United Utilities Water PLC
Developer Services & Planning
Warrington North WWTW
Gatewarth Industrial Estate
Off Liverpool Road
Sankey Bridges
Warrington
WA5 1DS

Your ref: 3/2013/0485
Our ref: DC/13/2288
Date: 28-JUN-13

Location: Roadsider Farm Preston Road, Longridge Lancashire PR3 3BL
Proposal: Proposed two storey detached dwelling with integral garage

1307/01
 Roadside Farm
 Preston Road
 Alston
 Nr Longridge
 Scale: 1/1250

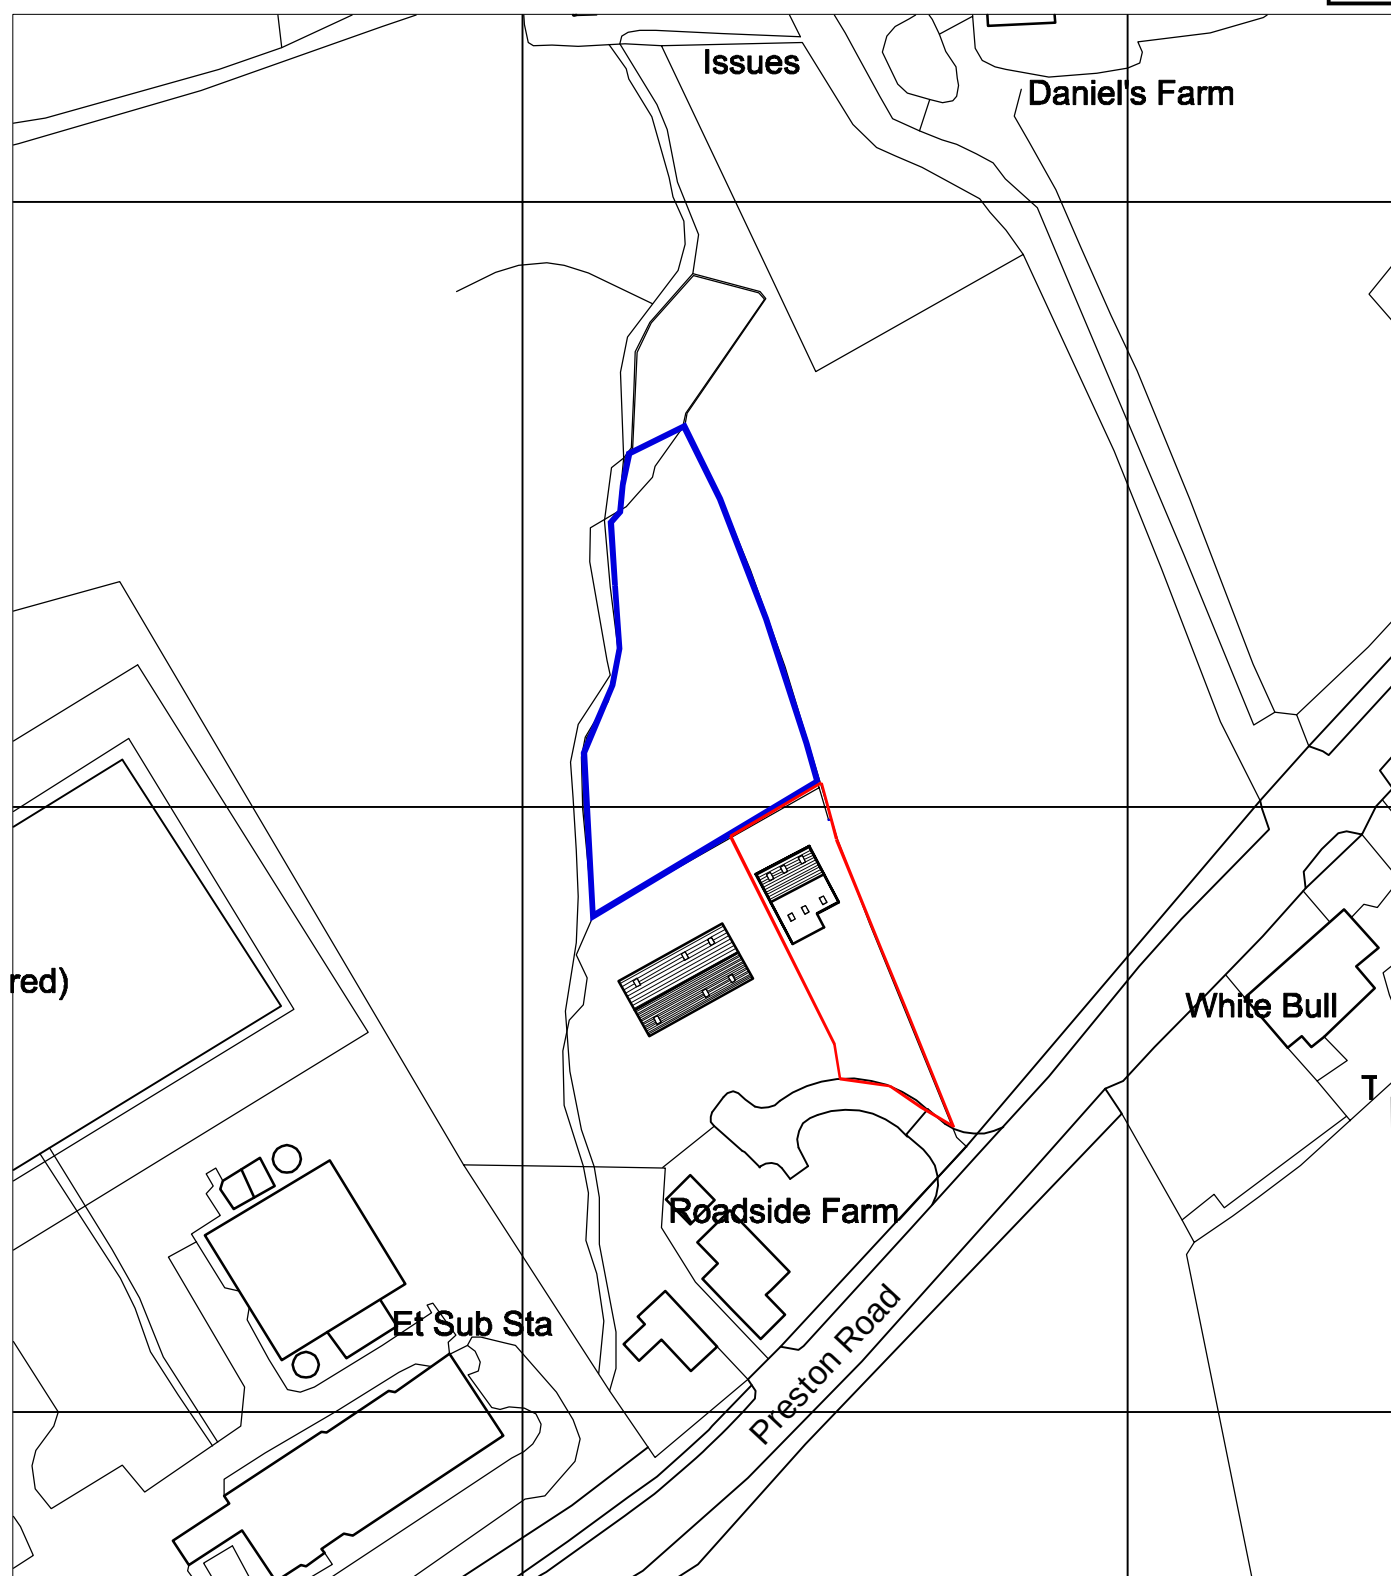
I will have no objection to the proposal provided that the following conditions are met: -
A large diameter raw water main crosses the site. As we need access for operating and maintaining it, we will not permit development in close proximity to the main.

- A modification of the site layout, or diversion of the main at the applicant's expense, may be necessary.

This should be taken into account in the final site layout, or a diversion will be necessary, which will be at the applicant's expense.

You will need an access strip of 10m.
